From: Chris Slade [REDACTED]
Sent: 02 September 2020 13:05
To: Ben Smith
Cc: Kieran Naphine [REDACTED] Luke Honeywill
Subject: RE: AL/51/20/PL - Tyrone House - PRE COM CONDITIONS DRAINAGE AND TREES
Attachments: C1340_100_P1_Drainage Layout.pdf; C1340_300_P2_Drainage Details.pdf; C1340_400_P_Impermeable Areas.pdf; C1340_Flow Report_A.pdf

Thank you for reconsulting us on this application. The information submitted is insufficient to avoid the need for pre-commencement conditions.

| DRAWING TITLE<br>DRAINAGE LAYOUT          |            |          |            |             |     |

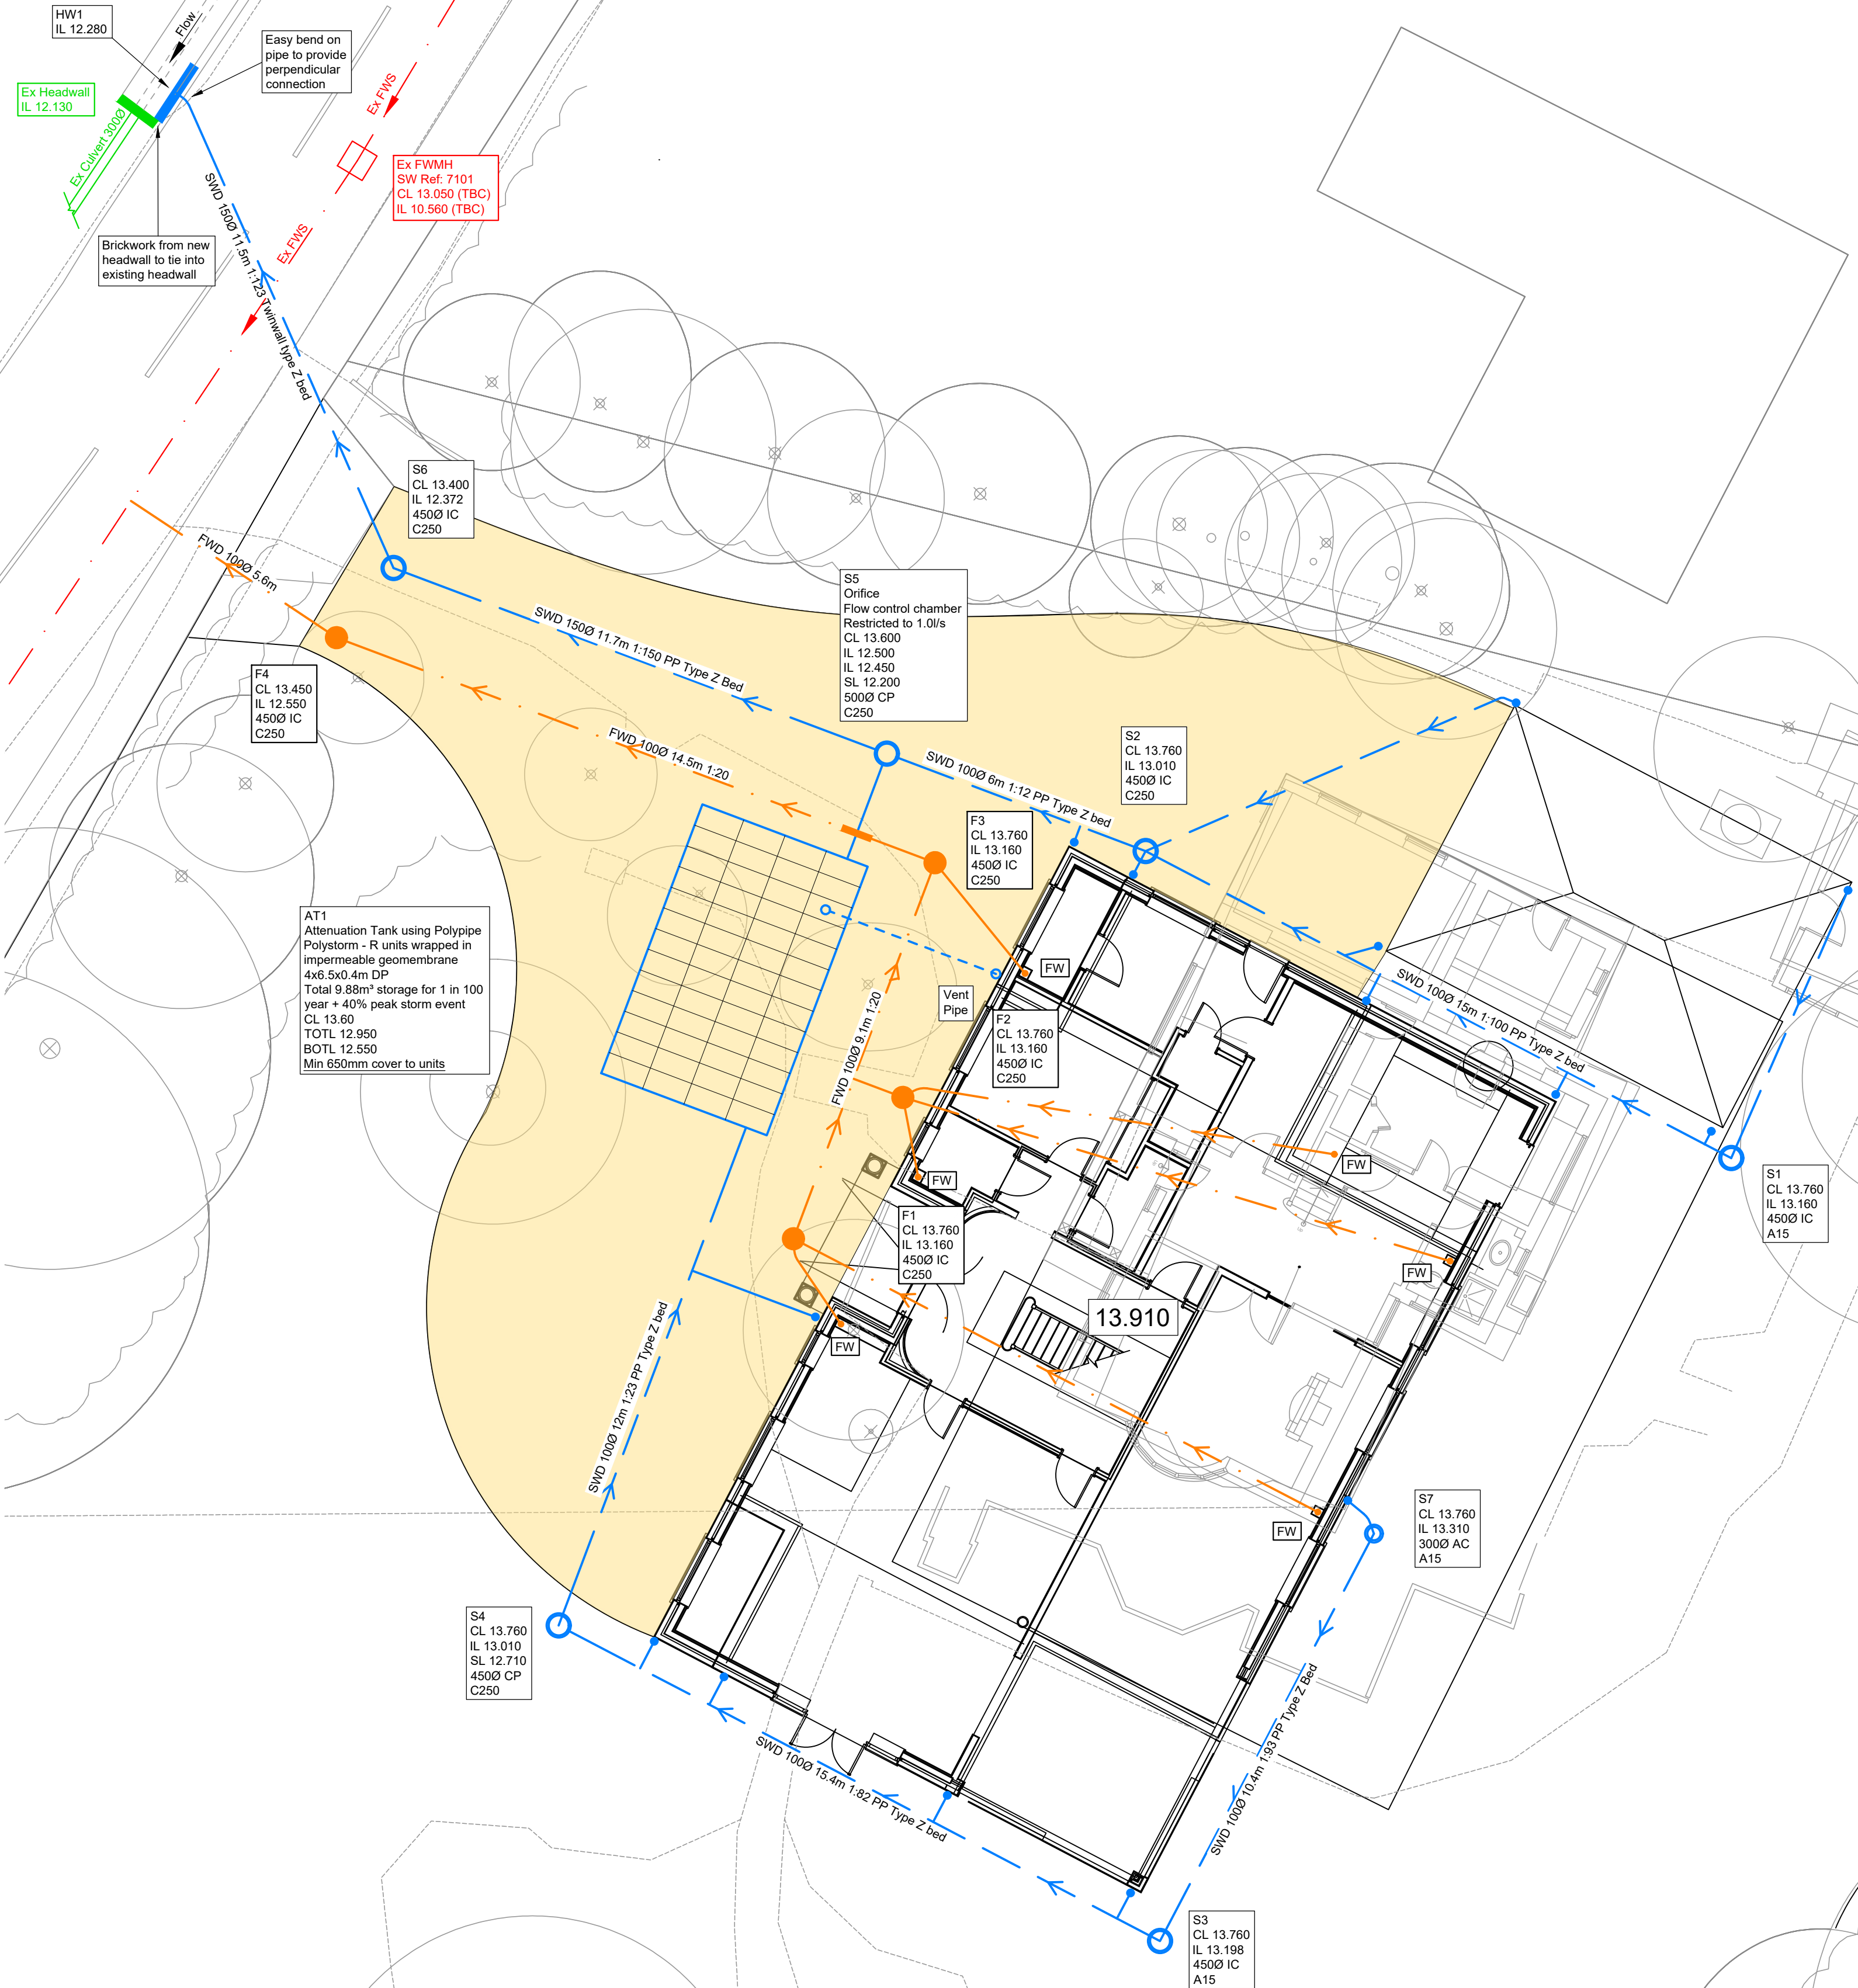
2. The drawing supplied shows a proposed connection to ordinary watercourse against the direction of flow, an alternative connection location is required.

- 2. The drawing supplied shows a proposed connection to ordinary watercourse against the direction of flow, an alternative connection location is required. Updated to reflect this.*

Formpave permeable block paving construction

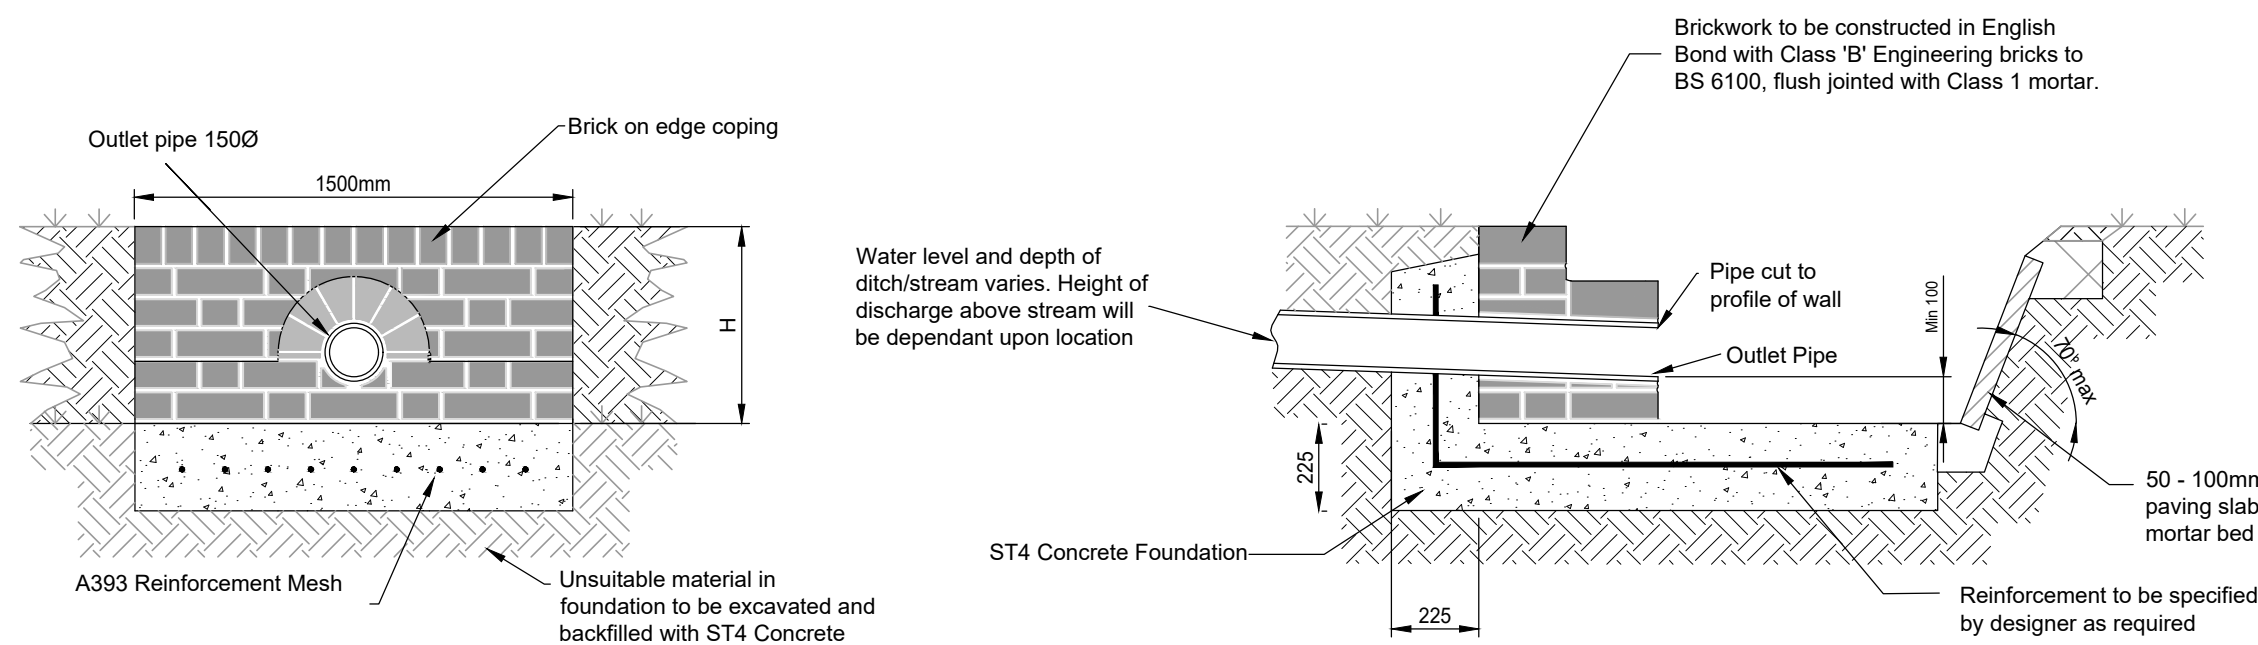
4. An impermeable areas plan must be provided.
5. Construction detail drawings of permeable paved area must be provided to evidence that this will have a fully permeable construction.

- 4. An impermeable areas plan must be provided. Find attached.*
- 5. Construction detail drawings of permeable paved area must be provided to evidence that this will have a fully permeable construction. Updated details drawing to show this.*
